From: ENVU Biodiversity and Land Use
Sent: 29 September 2025 11:33
To: Planning ContactCentre
Subject: 2025/90956 at location Moorlands Cricket Club, Mirfield Memorial Park, Huddersfield Road, Mirfield, WF14 8AE

Please see an [updated](#) commentary below for this application:

Pre-Development Plan Baseline Map

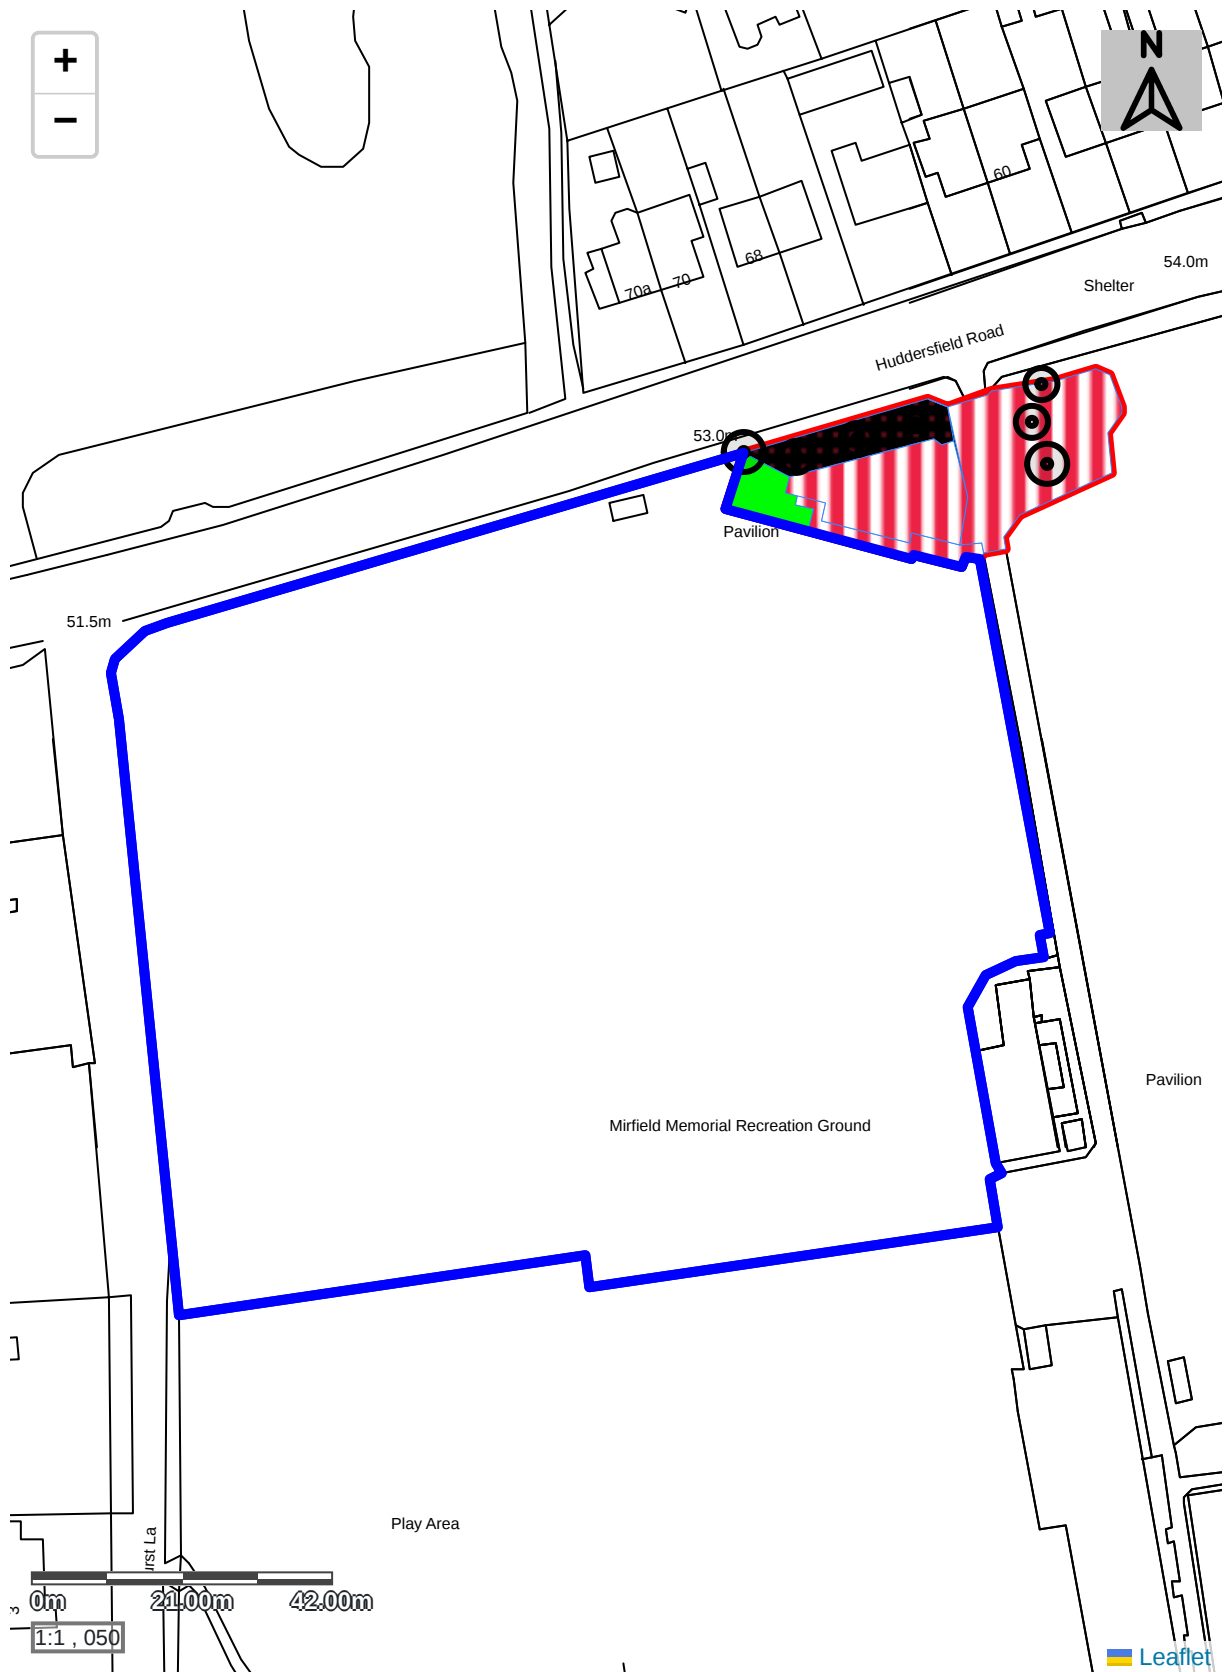
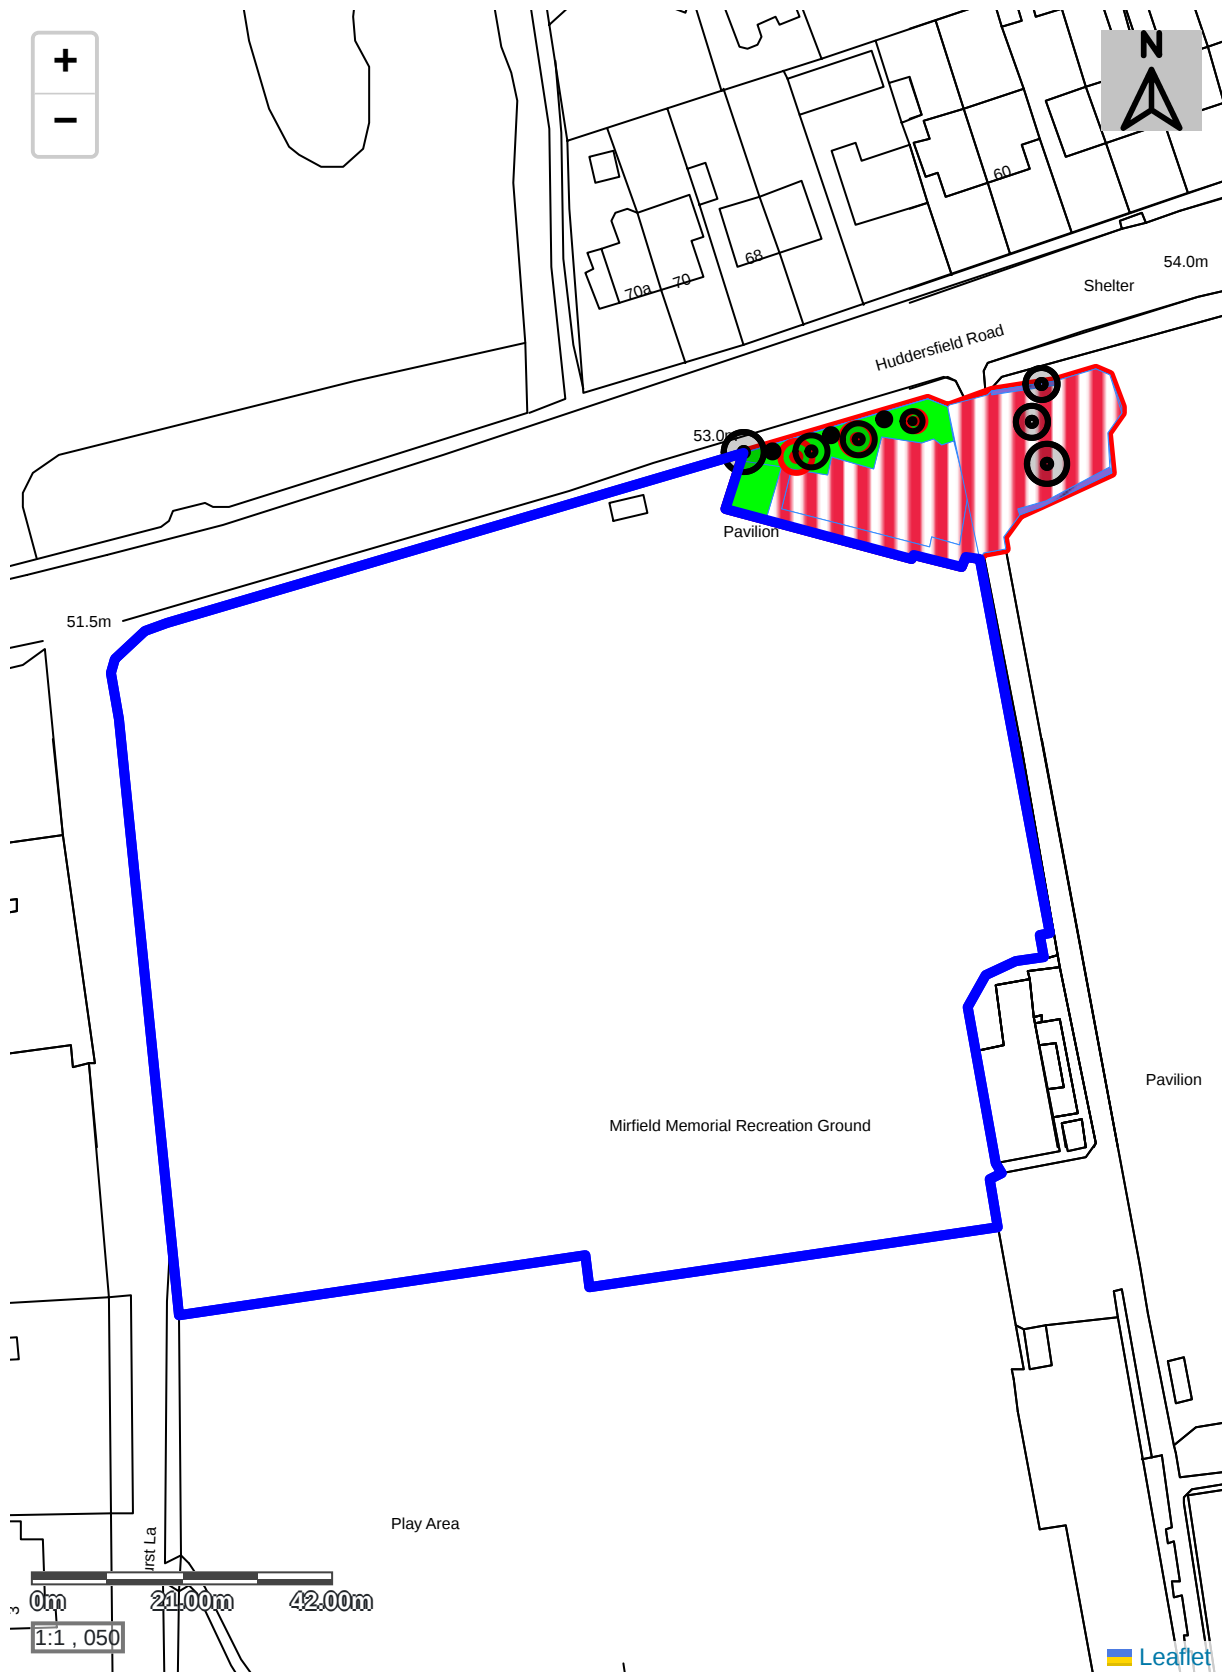
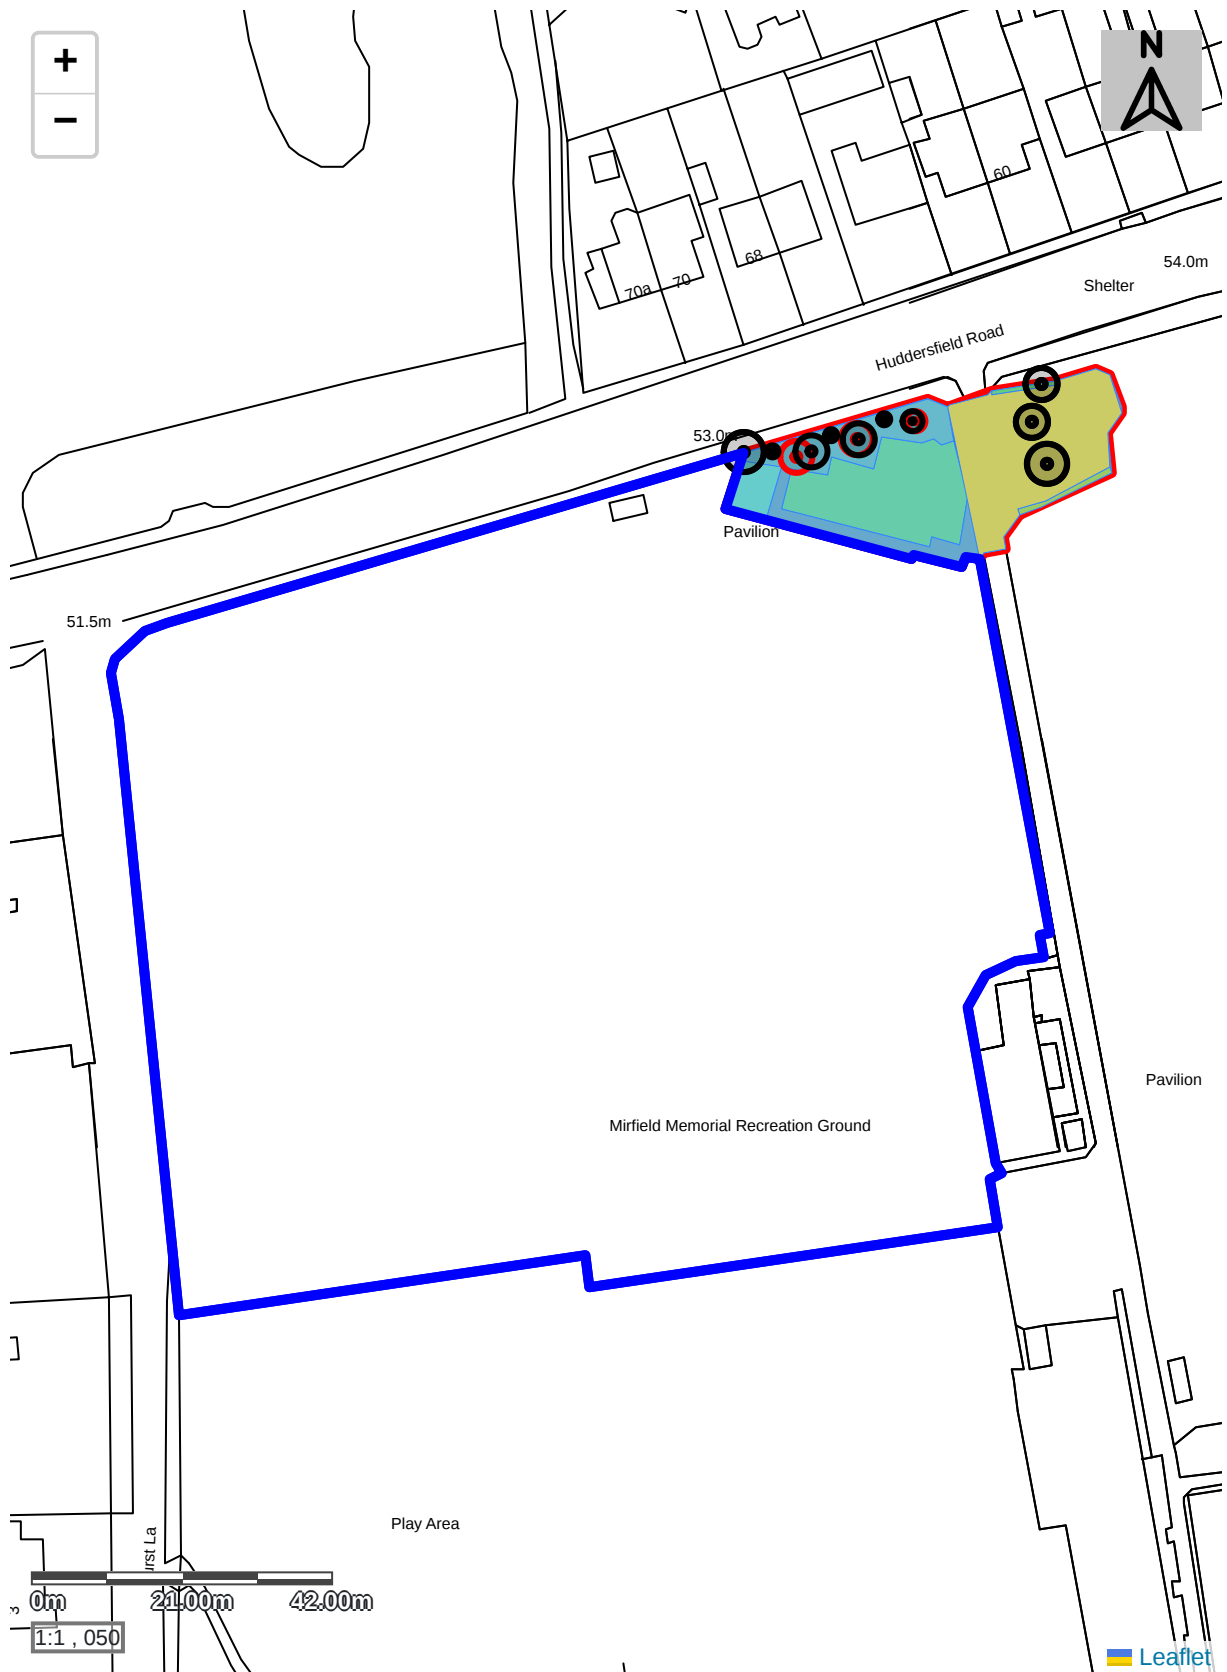
There is a lack of photos to demonstrate the habitats on-site.

There is no mention of a site walkover being completed.
